## **Development Facilitation Team (DFT) – Review Comments**

**DRB Project No: PR-2020-003484 Date: 04/12/2023 Agenda Item: #1 Zone Atlas Page: E-10**

### **Application For: SD-2023-00048 – PRELIMINARY PLAT (DHO)**

DRB Project Number: 2020-003484 Hearing Date: **01-11-2023**  
 Project: Mojave Ridge Subdivision Agenda Item No: 1

PRELIMINARY PLAT FOR  
**MOJAVE RIDGE SUBDIVISION**  
 (A REPLAT OF LOTS 2 & 3, BLOCK 12,  
 UNIT 3, VOLCANO CLIFFS SUBDIVISION)  
 WITHIN  
 SECTION 27,  
 TOWNSHIP 11 NORTH, RANGE 2 EAST, N.M.P.M.  
 CITY OF ALBUQUERQUE  
 BERNALILLO COUNTY, NEW MEXICO  
 JANUARY, 2023

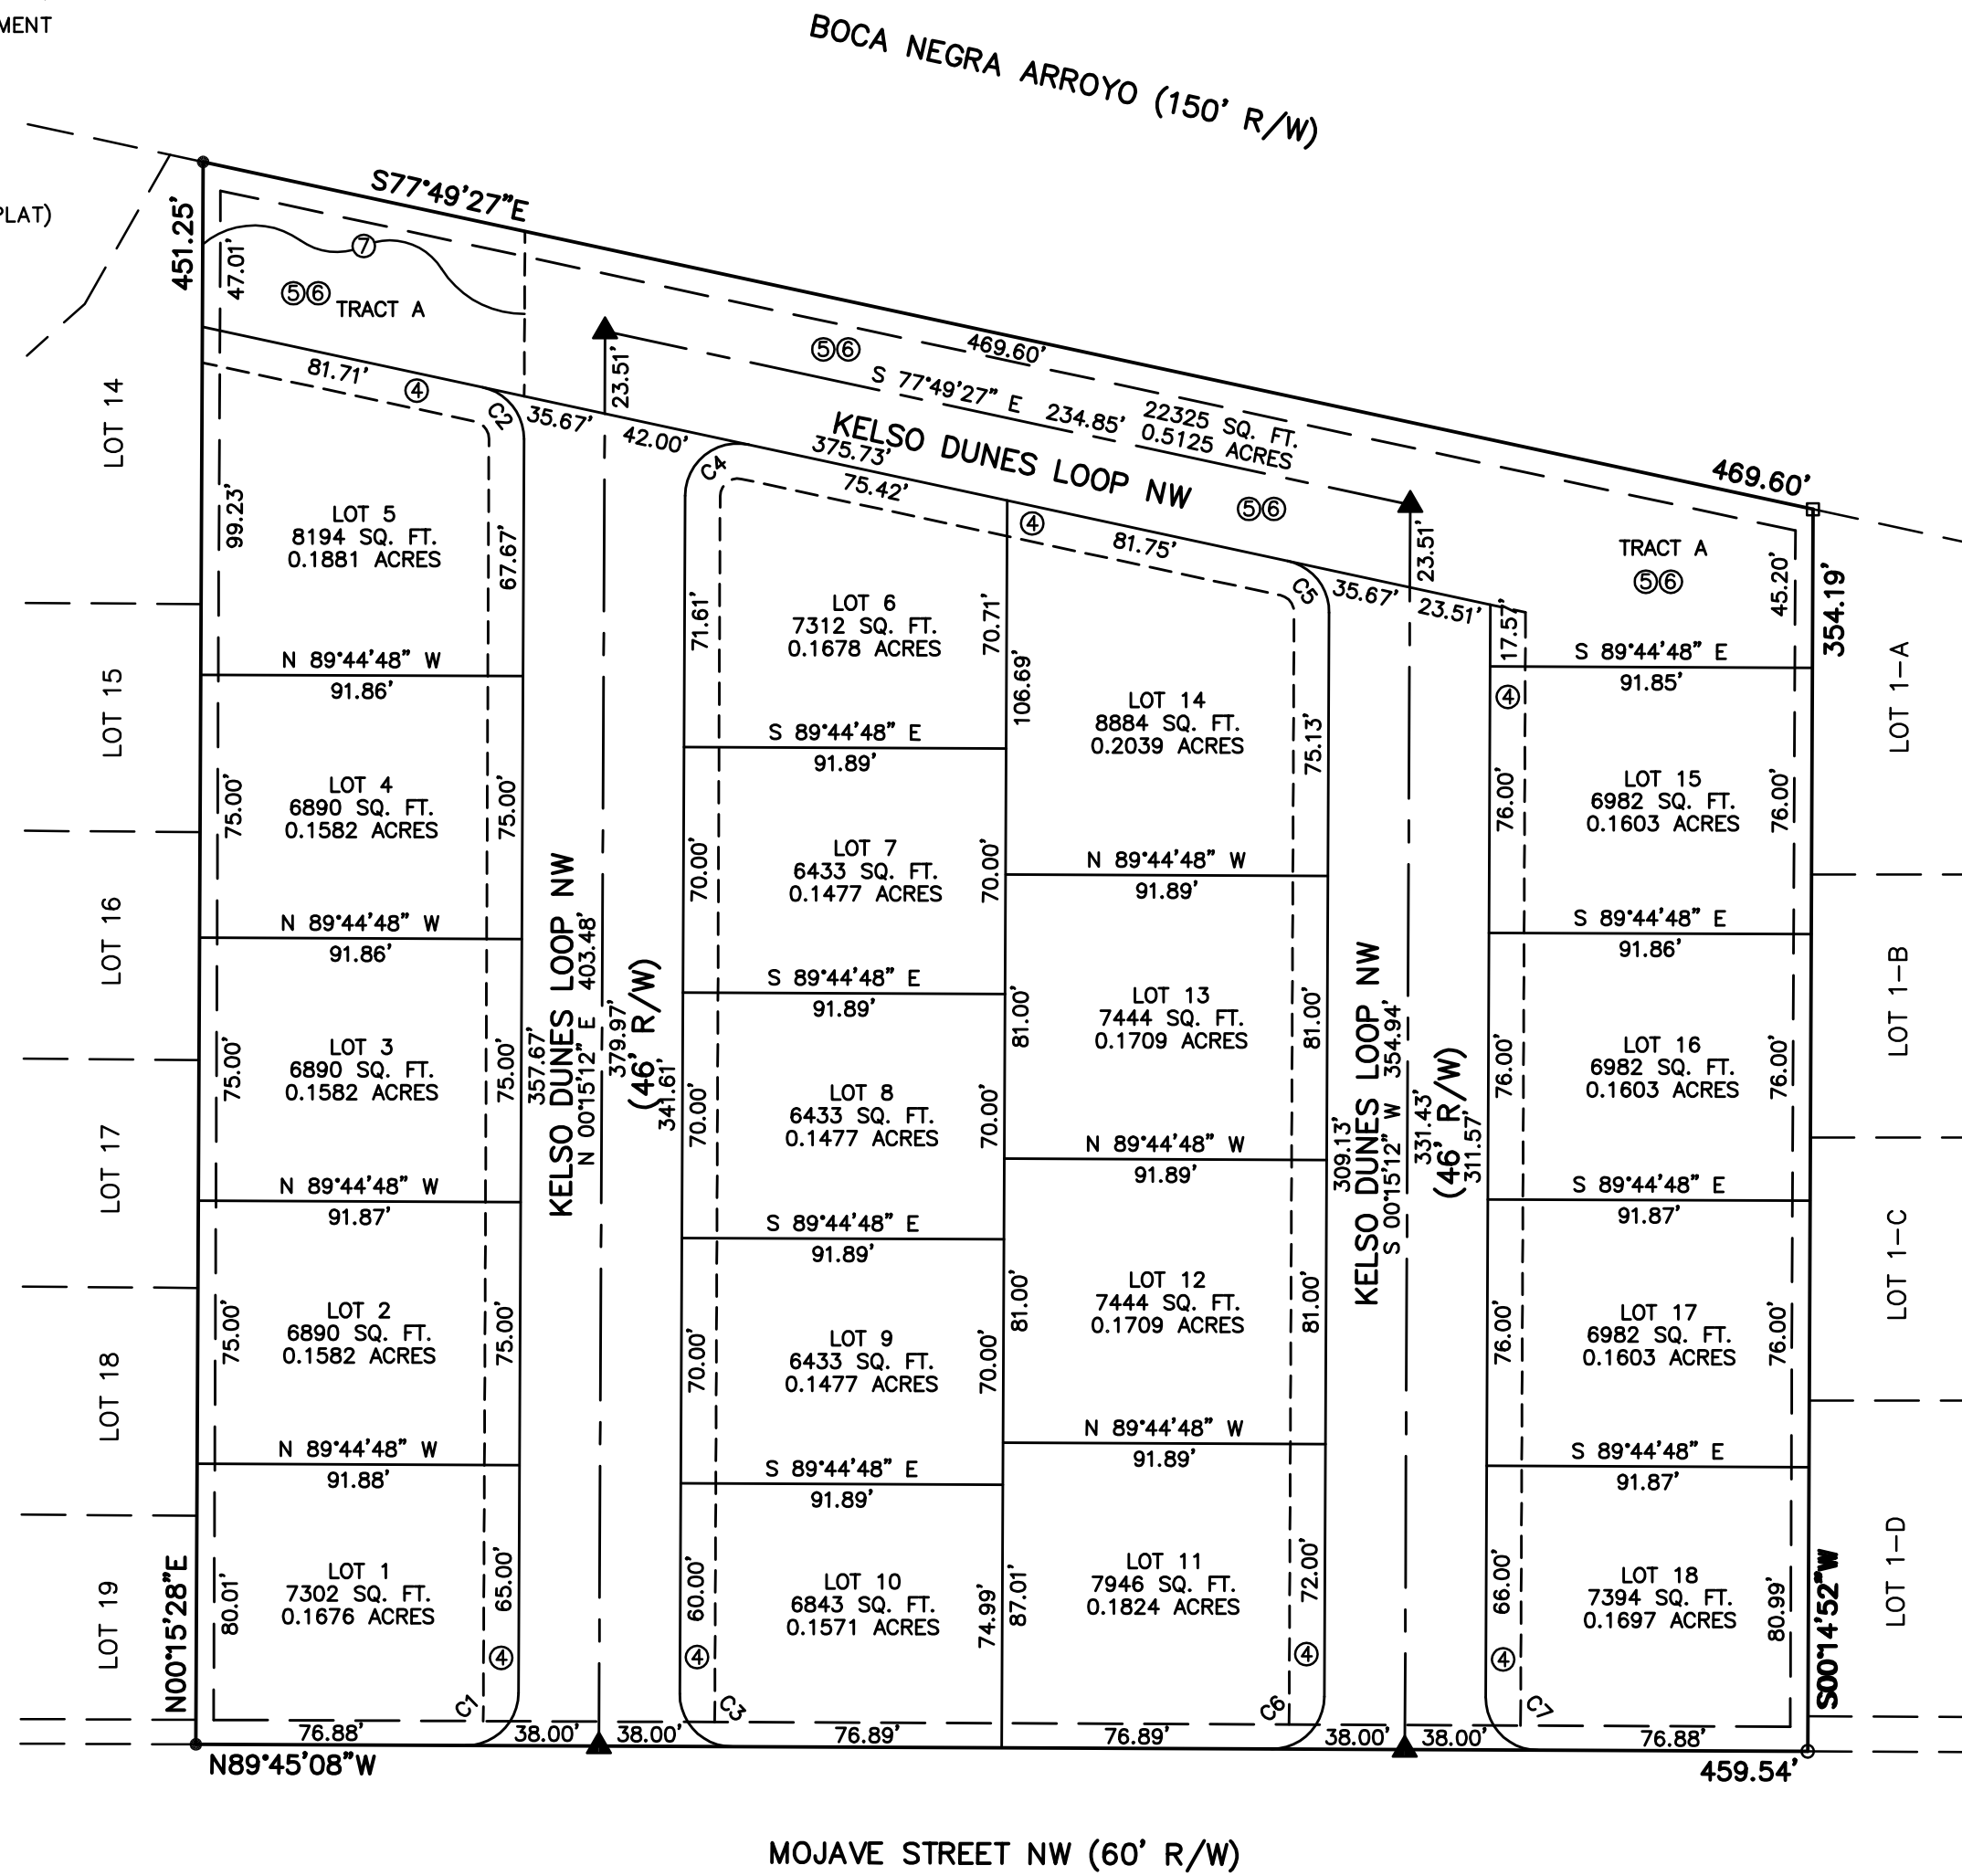
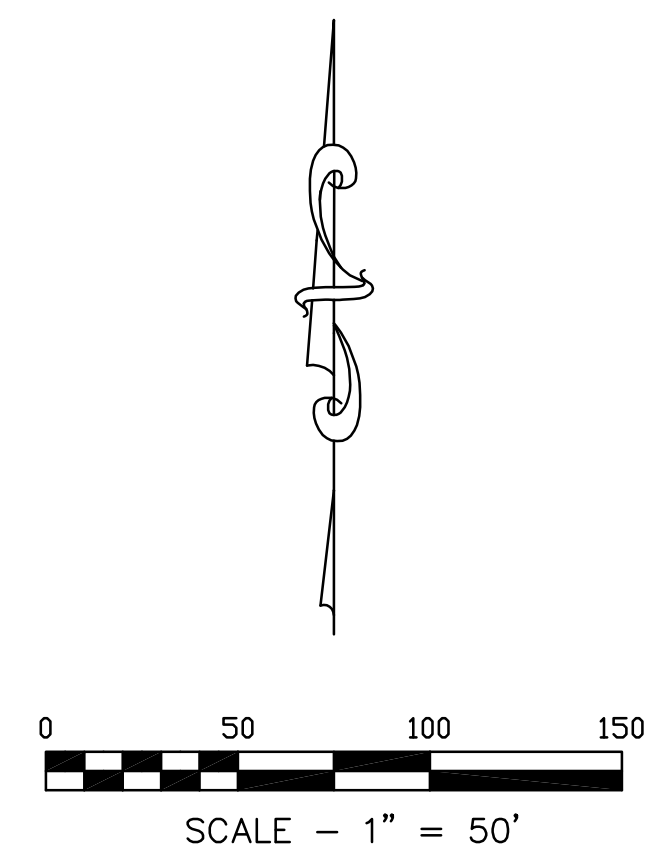
- Hydrology has an approved Grading & Drainage Plans (E10D024) with engineer's stamp date of 11/14/22.
- The Public Drainage Easement on Tract A needs to be change to state, "To be maintained by the HOA.". An Agreement & Covenant will need to be filed prior to Final Plat.
- Infrastructure List – This needs to be changed. Please have separate line items for the Scour Wall and the Stormwater Quality Pond. Also, the storm sewer line item should be listed as "Storm Drain with Double Type C Inlets" instead of two separate line items.

- Tract A: Is there a landscaping Plan for Tract A? Any Landscape Plans must be sealed and signed by a Landscape Architect licensed in the State of New Mexico.  
**Change the maintenance note of Tract A to be the Homeowner's Association;** city maintenance is not provided for Tract A.

- c. Any damaged areas noted shall be restored per contractor expense.
- 5-2 (J)(2)(a) Lot 5 is abutting the Boca Negra arroyo. Add a note to the plat indicating that the 45 feet buffer abutting the Petroglyph National Monument must have plant approval and location per the Open Space Superintendent.
